*Third Party Submission to Referral –
ABP-302770-18
(PA Reg Ref: P/DC/3/15/18)*

“Whether the conversion of a ground floor office space and seminar room to a one-bedroom studio apartment is or is not development or is or is not exempted development”.

*Ti Choinn, Gleann na Ri, Murrough, Galway
City*

Gleann na Ri Management Company

01 Ground Floor Plan
 Scale: 1:100
 Unit Building area 750.88sqm
 Proposed volume area: 104 sqm

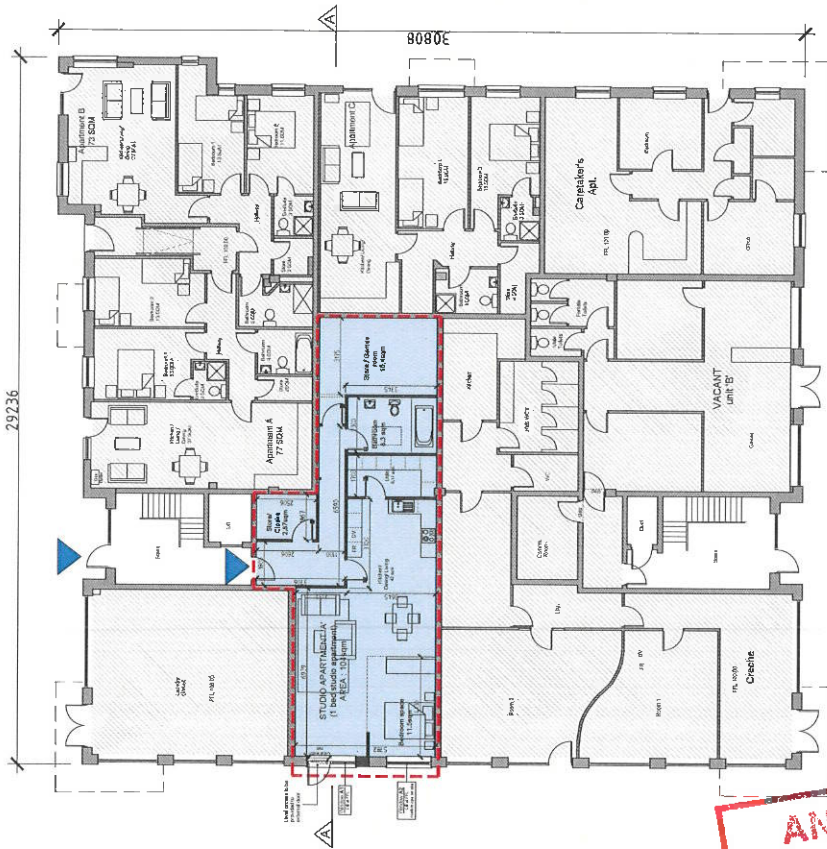
6(d)(v) <i>"No development shall consist of or comprise the carrying out of works which exceeds the provision of more than 9 residential units in any structure."</i>	We understand this criteria was designed to ensure that Part V requirements (Social Housing), are not avoided. At present (as indicated on the drawings accompanying Pl. Ref. No. 15/359), there are 17 no. units within the structure. The proposed development could facilitate a total of 18 units. Furthermore, we refer to the parallel Referral (ABP-302769-18), which would facilitate the provision of 19 residential units within the structure. As the proposal would facilitate additional residential development in excess of the 9 unit threshold, the proposed development cannot be considered exempted, and would also circumvent Part V requirements.
6(d)(vi) <i>"Dwelling floor areas and storage spaces shall comply with the minimum floor area requirements and minimum storage space requirements of the "Sustainable Urban Housing: Design Standards for New Apartments — Guidelines for Planning Authorities" issued under section 28 of the Act or any subsequent updated or replacement guidelines."</i>	At face value, the proposed drawings would appear to comply with the latter criteria. However, owing to the continued function of the common services within the "Stairs Store" room, and the inability to relocate the inherent trip switches, switchgear and water stop valves in this area, the proposed private "Store/Cloaks Room" cannot be provided as part of the proposed studio apartment. In these circumstances, the proposal cannot be considered exempted development.

In addition, the proposed drawings ignore the existence of essential common area services including the trip switches and switchgear of the building and the water stop valves of seven apartments located on the first and second floors on the premises. I have outlined the location of these services on the attached drawing. It is vital that the management company maintains access to these essential services.
